Re: **Double Eagle II Airport Aircraft Hangar (Tri-Motor)**
Grading and Drainage Plan for Grading, Paving, and Building Permits
Engineer's Stamp dated 7-15-08

RE: Double Eagle II Airport Aircraft Hangar
Grading & Drainage Plan for Grading, Paving
and Building Permits
(E06/D001A)

Re: Double Eagle II Airport Aircraft Hangar (Tri-Motor)
Grading and Drainage Plan for Grading, Paving, and Building Permits
Engineer's Stamp dated 4-10-08 (E06/D001A)

C-103A

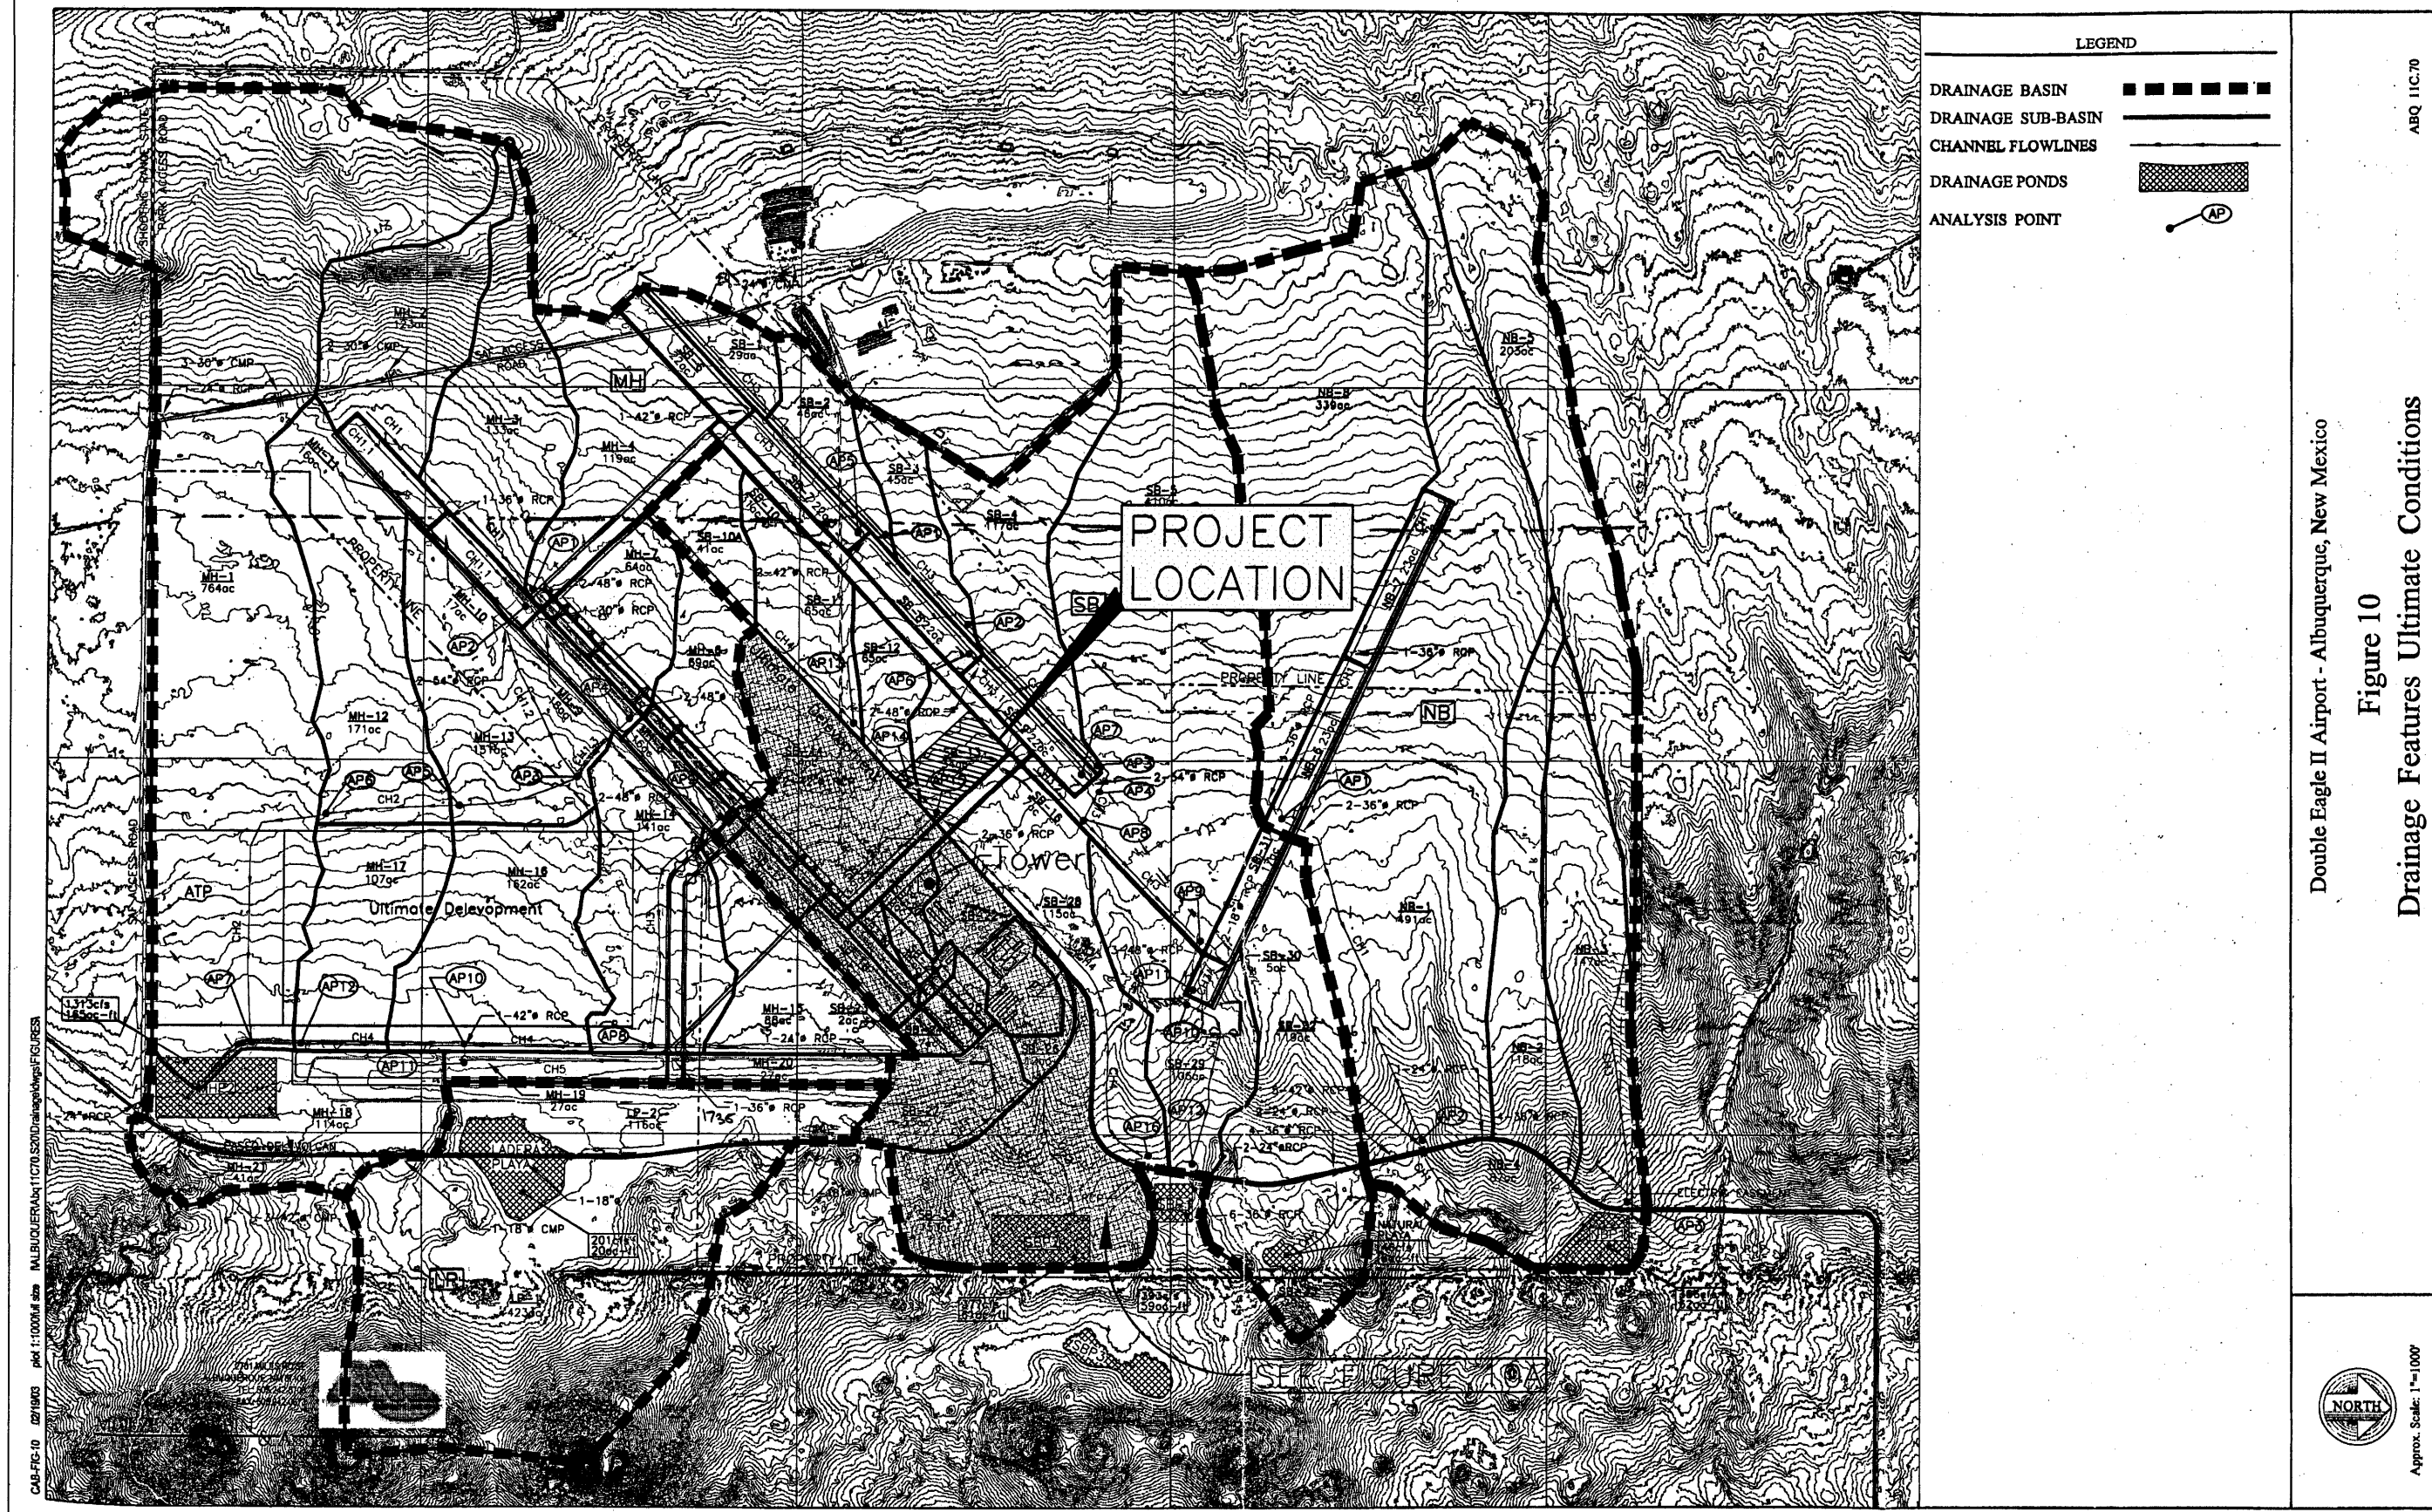
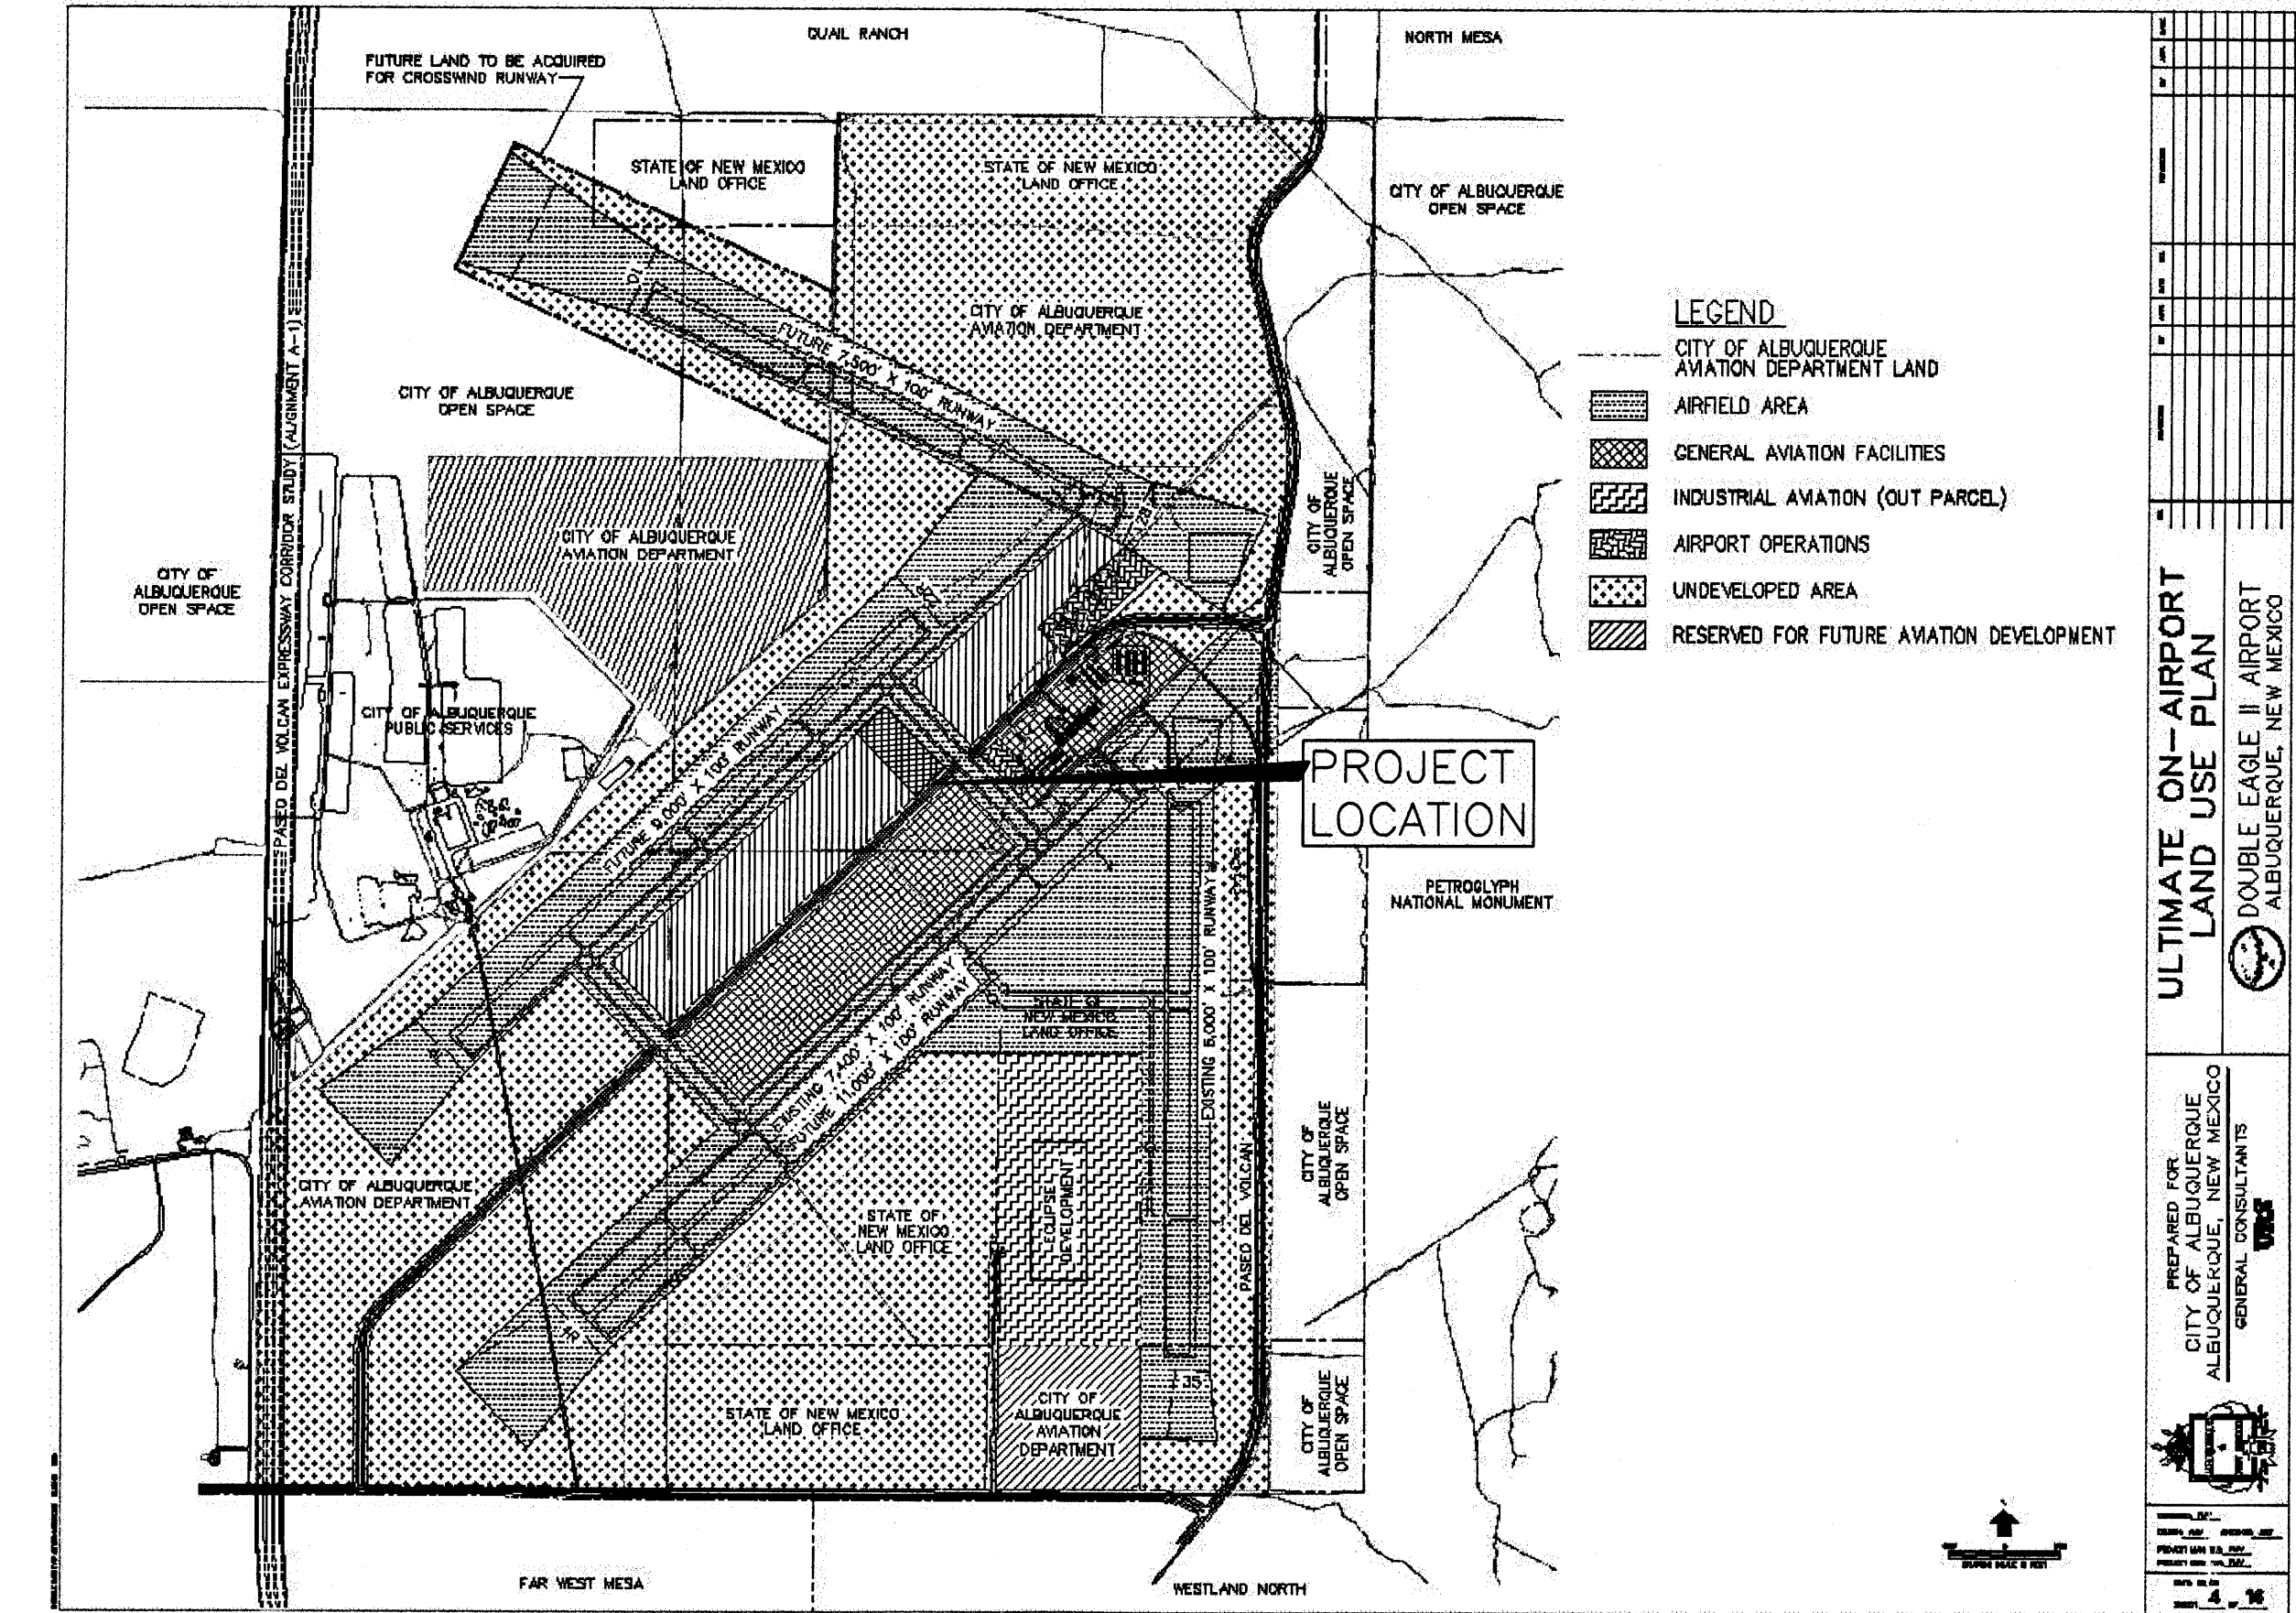
COA Comment: *"The plan indicates that there is an offsite flow of 9.0 cfs, but does not show where it enters or leaves the site. Labeling inflow and discharge points on the plan with flow arrows and rates would facilitate our review."*

MCA Response: See attached Sheet C-103A, Exhibit-A.
